Sent: 15 June 2012 11:03
To: Planning
Subject: Planning application N6/2012/1094/FP - 47- 49 Burrowfield

Response to Planning application from Hertfordshire County Council (T and CP GDP Order 1995)

District ref: N6/2012/1094/FP
HCC ref: WH/252/2012
HCC received: 12/06/2012
Area manager: James Dale
Case officer: Lindsey Lucas

Proposal
Retention of new office building and security fencing and gates

Title:
Proposed new office building
47-49 Burrowfields
Welwyn Garden City
Herts AL7 4SS
Site Plan

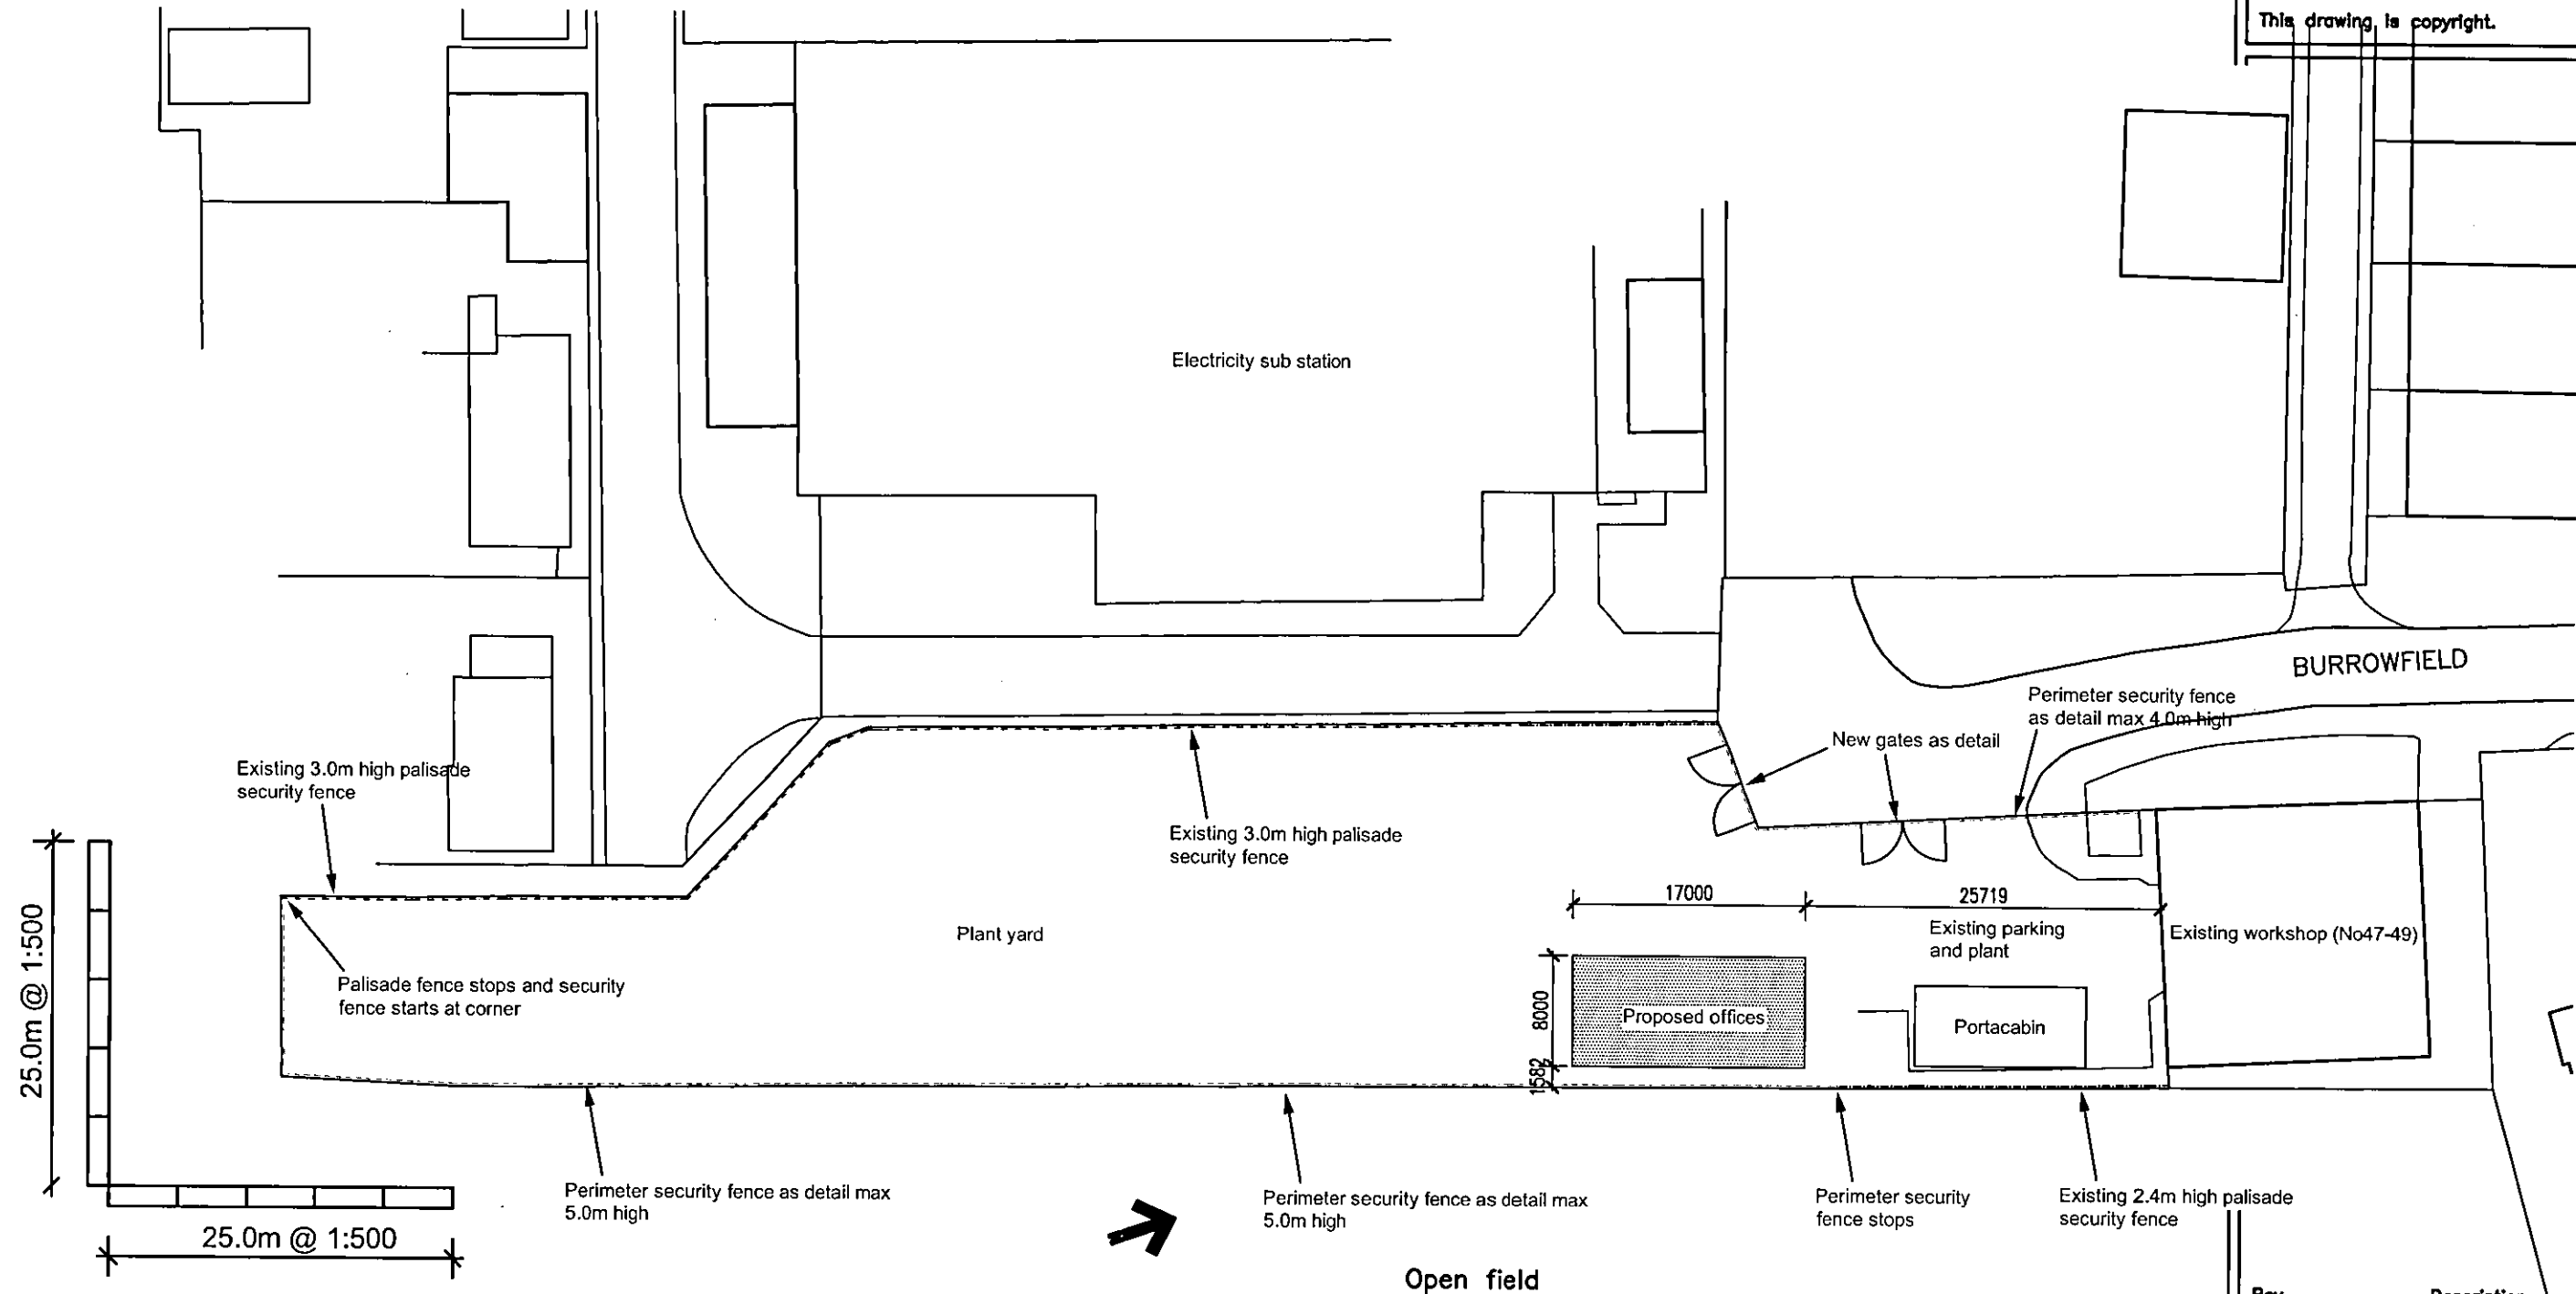
The proposal is for the retention of new office building and security fencing and gates. Burrowfield is a local access road and serves a number of industrial properties. Although the Design and Access statement states that there is space on site available for parking, no parking layout plan has been provided to show how the area for parking relates to the areas required for the manoeuvring of the Ready Mix vehicles. From my site visit I also noticed that cars park perpendicular to the building marked as "existing workshop" on the Site Plan number AT372-02, however there is no dropped kerb to serve these parking spaces and if they are to be included as part of the parking provision for the site then a dropped kerb should be provided. I

consider that if permission is granted then it should be conditional on the submission of internal layout plans which clearly indicate which areas are for vehicle parking, vehicle manoeuvring and for the storage of materials. This will ensure there is sufficient space within the site to accommodate all the vehicles associated with the proposal. The proposal will not result in a significant increase in vehicle trips to the site.

1. Prior to commencement of the development hereby permitted, a site layout plan showing the area set aside for car parking, vehicle turning and site storage shall be submitted to and agreed in writing by the local planning authority and highway authority.

2. C8.12 - The area set aside for parking shall be laid out and surfaced before the development hereby permitted is first occupied and shall be retained permanently there after for the accommodation of staff and shall not be used for any other purpose.
